PORTLAND MAINE

October 4, 2010

Re: 91 Auburn Street – 375 C001 – B-2 – pylon sign for CVS - #10-0995

Existing Signage - Elevation

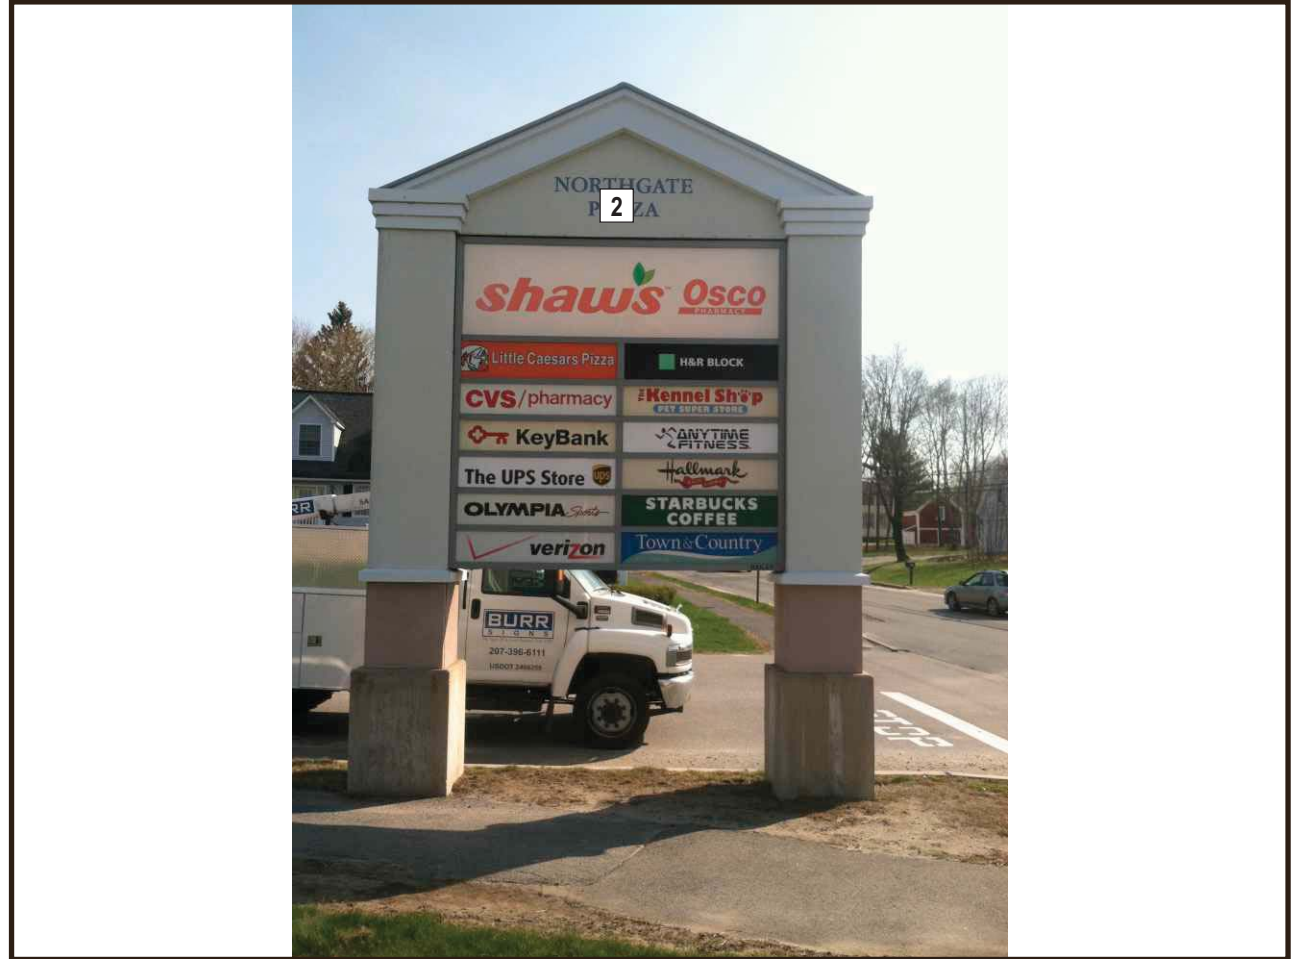
I finished my reviewed of the sign application to replace the pylon sign at 91 Auburn Street for CVS, Mercy Primary Care Center and Shaw's, and called you on August 23, 2010. I told you that the pylon sign is legally nonconforming and therefore it cannot be increased in size. This means that the total square footage of it cannot increase and the height from grade to the top of the sign cannot increase. The pylon sign is legally nonconforming because the ordinance does not allow for two pylon signs on the same frontage [section 14-369.5, Table 2.13]. This pylon sign and the other pylon sign on Auburn Street were permitted before this section of the ordinance went into effect so they are both legally non-conforming and cannot be increased in size.

I asked you to provide me with the total square footage of the signage of the existing pylon sign (CVS Pharmacy, Mercy Primary Care & Shaw's Osco) and the overall height of the existing sign from grade to the top. I need that information to determine if the square footage of the signage for the proposed sign or the height of the proposed sign is greater than the existing sign. From the plans that I received, the overall height of the proposed sign is 25'. The square footage for the CVS panel is 52.71 square feet and the Mercy/Shaw's panel is 39.93 square feet. I can't determine the square footage of the electronic message center because I don't know how wide it is. Until I get all this information, I cannot determine if the proposed sign is any larger than the existing sign.

If the proposed sign is bigger, than I cannot approve it. You must either modify it so it is no bigger than the existing sign, or you can appeal it. Section 14 – 368.5(g) of the ordinance states that an applicant who has been denied a permit or approval for failure to meet the signage regulations of section 14 – 369.5 “may apply to the planning authority for review of the denied signage pursuant to the standards set forth in section 14 – 526(a)(23)”. If the planning authority disapproves the application, then under section 14 – 527 of the ordinance you may appeal the decision to the Planning Board within ten (10)
